An  
Bord  
Pleanála

## Inspector's Report

### ABP-305844-19

685 residential units, crèche and associated site works

Drawing file: 305844 / 6384_307 Boundary Details - Entrance Design Old Dublin Road, (NTA Option).pdf

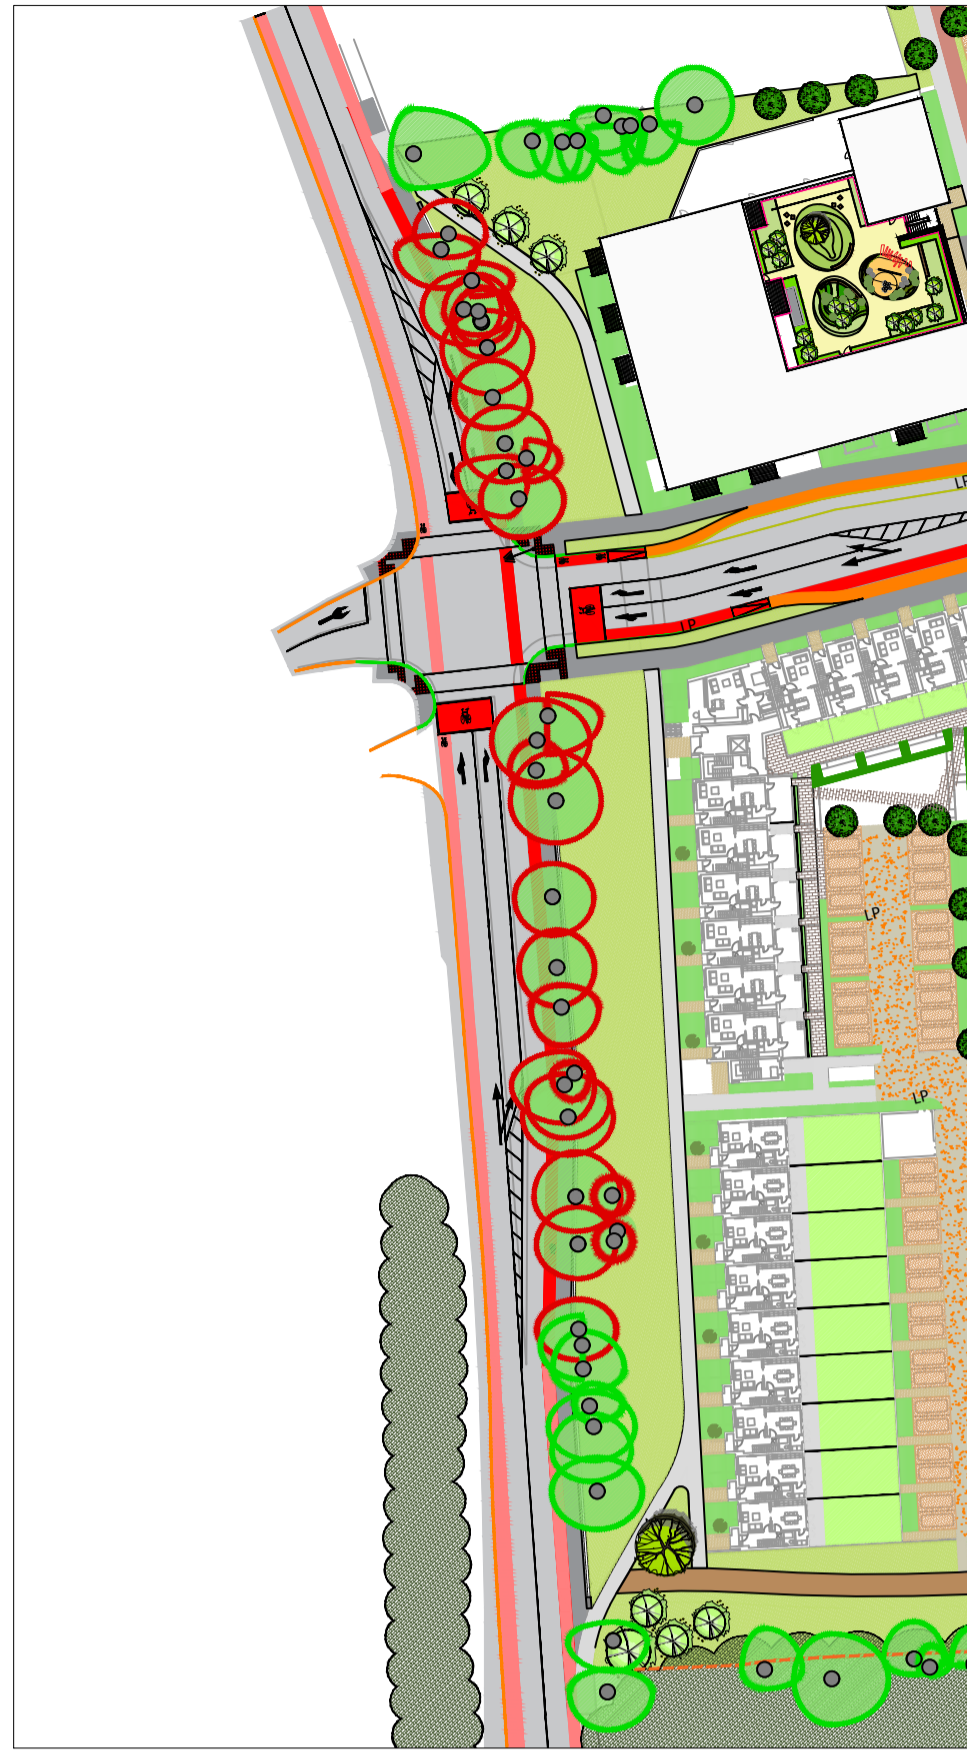
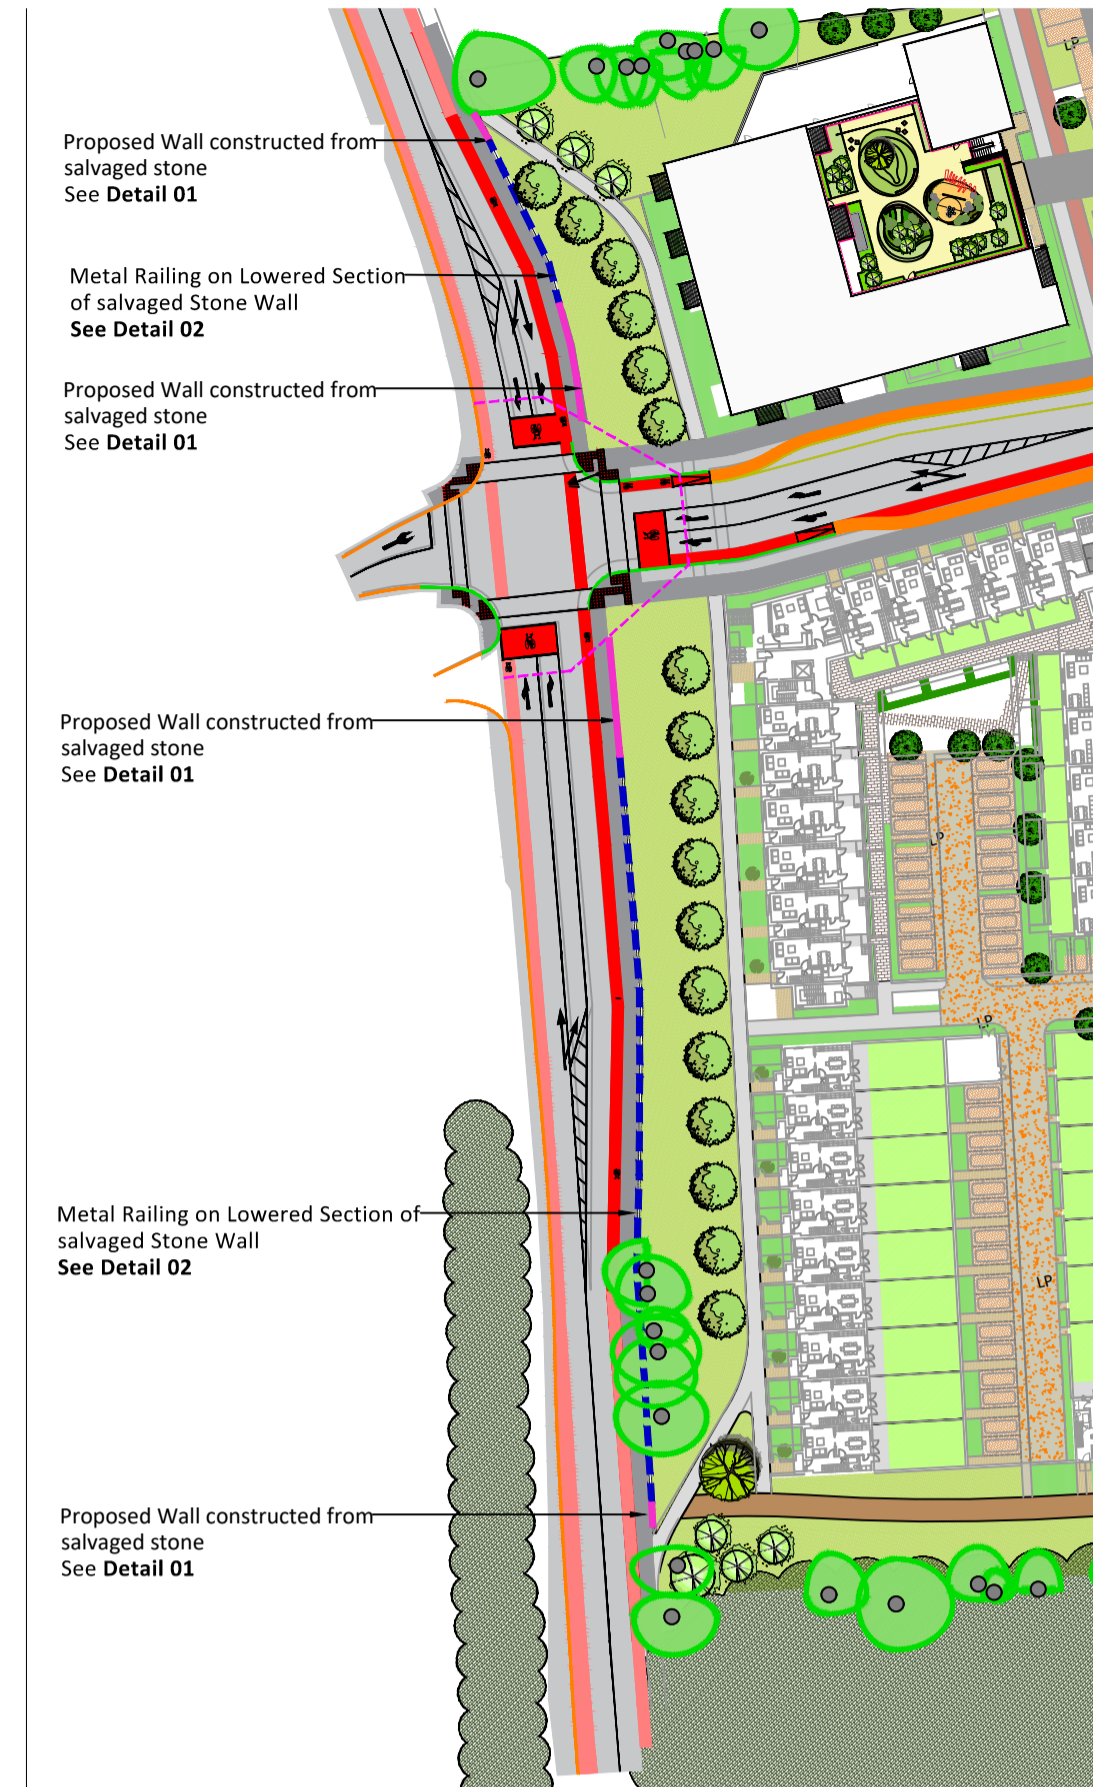
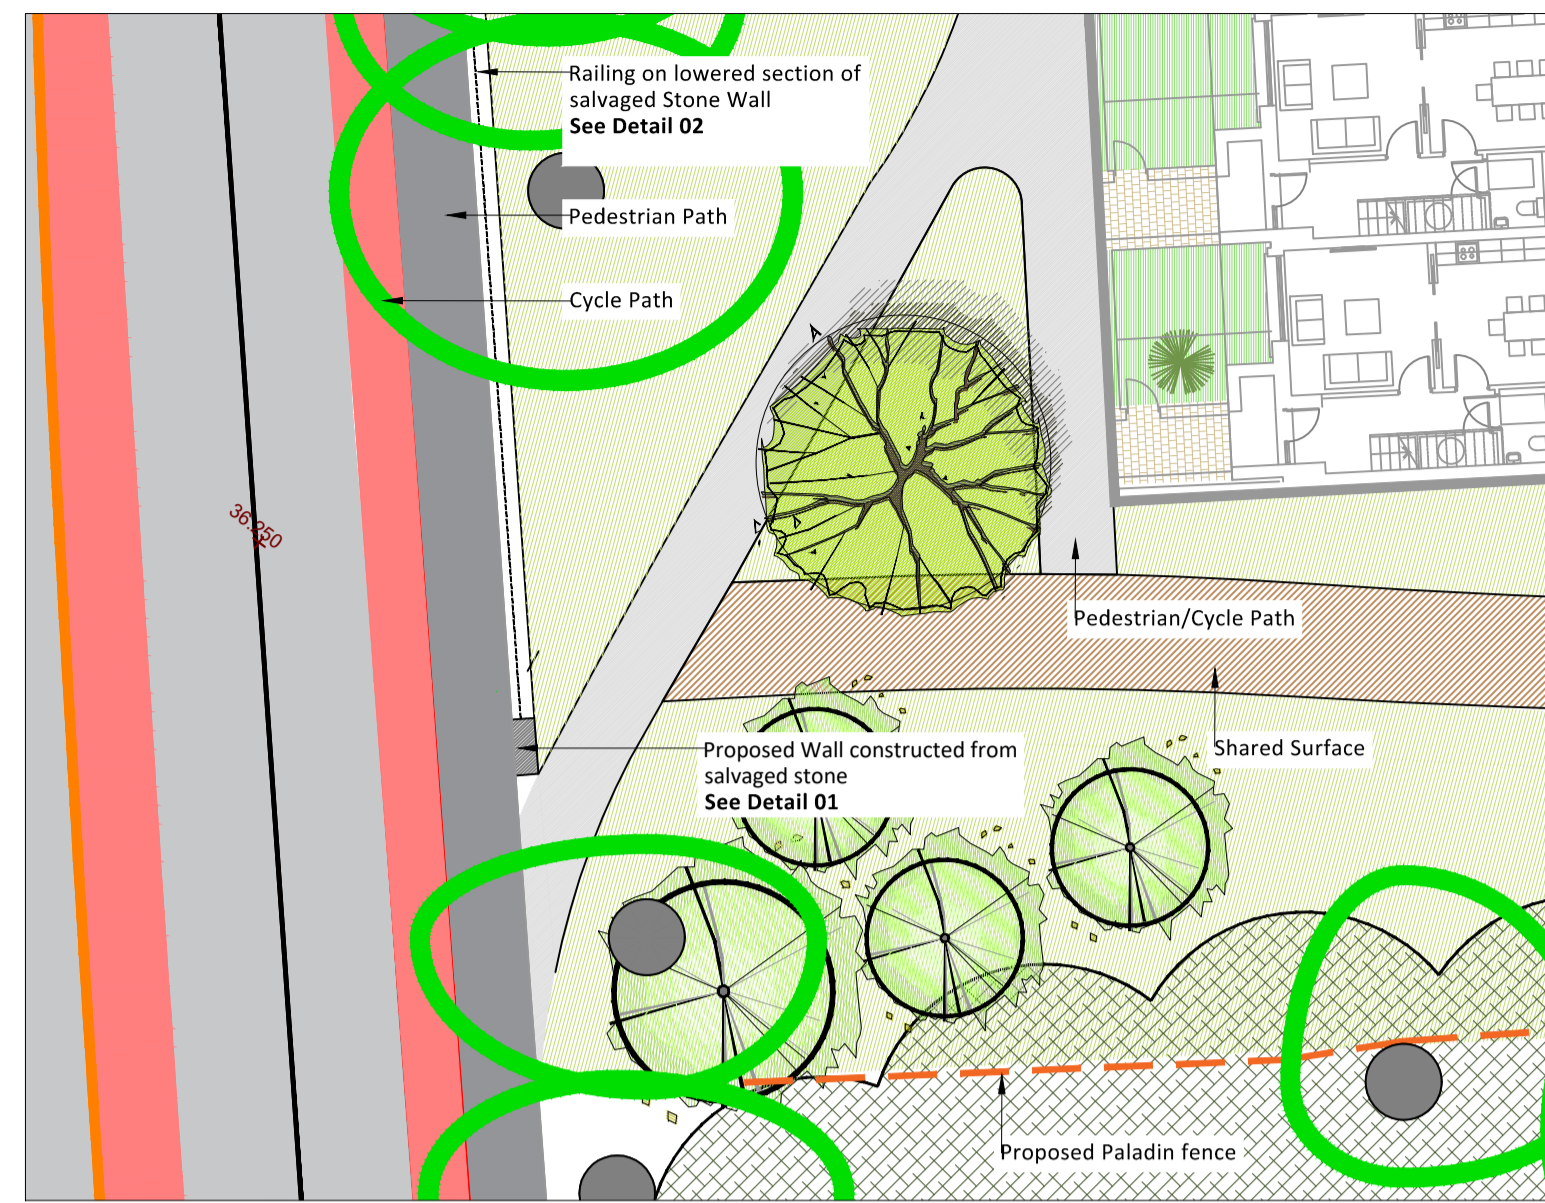
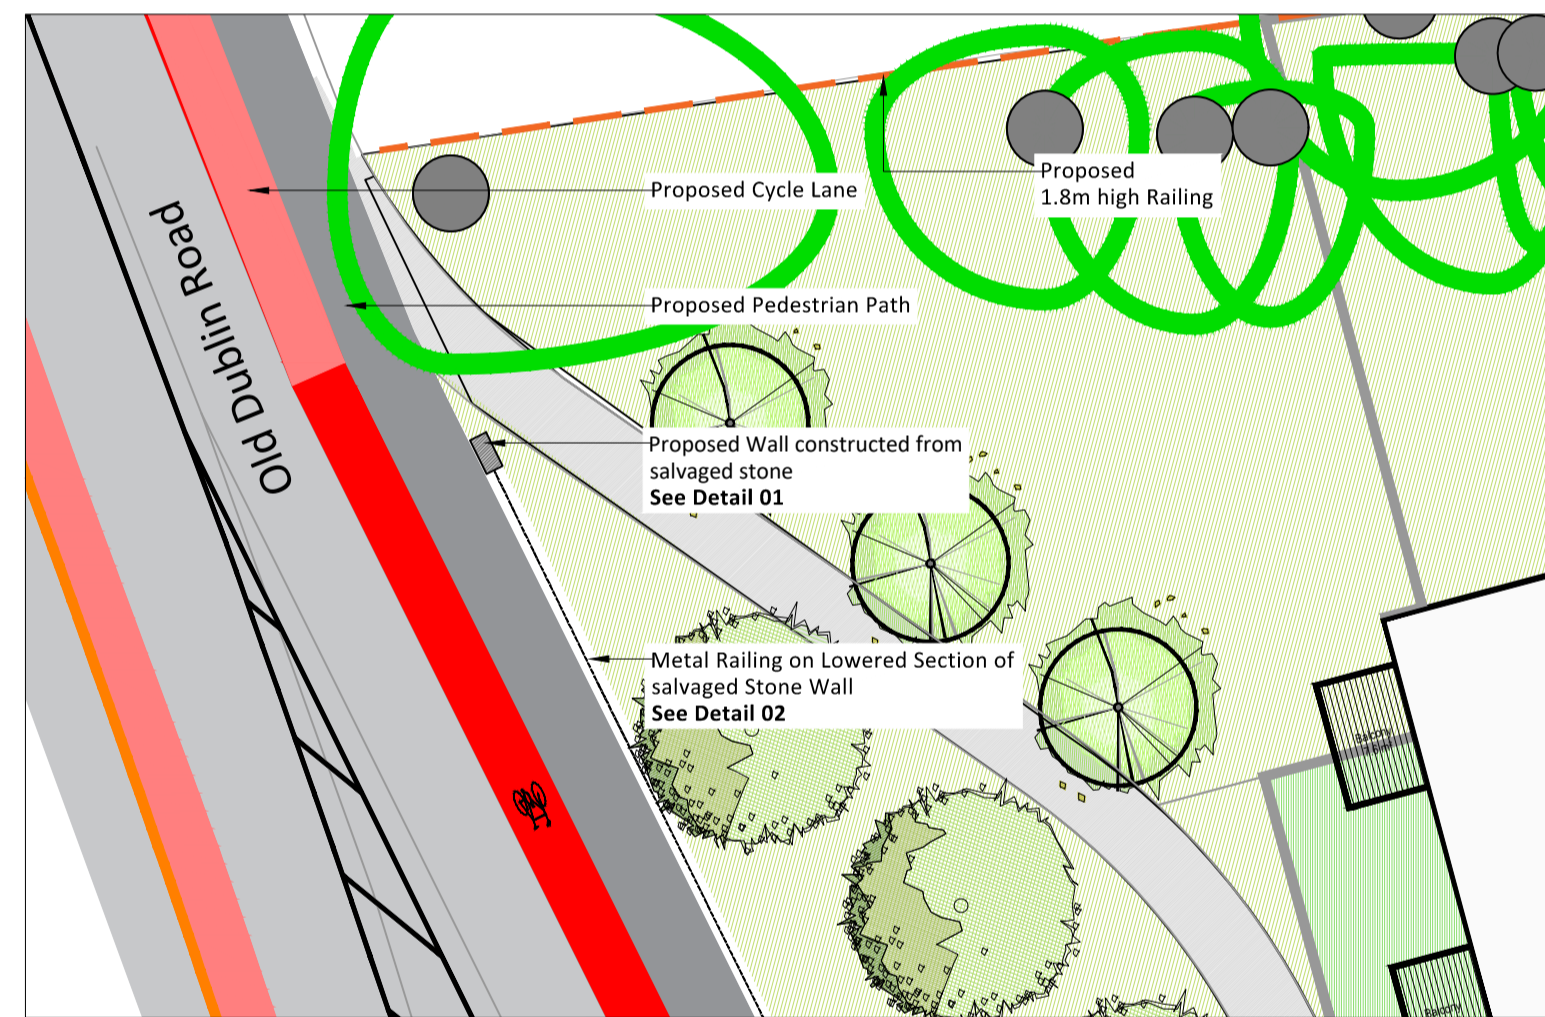
Option 2 in relation to proposed access on Dublin Road is preferred option as it offers a better transport solution for all road users, but particularly for cyclists
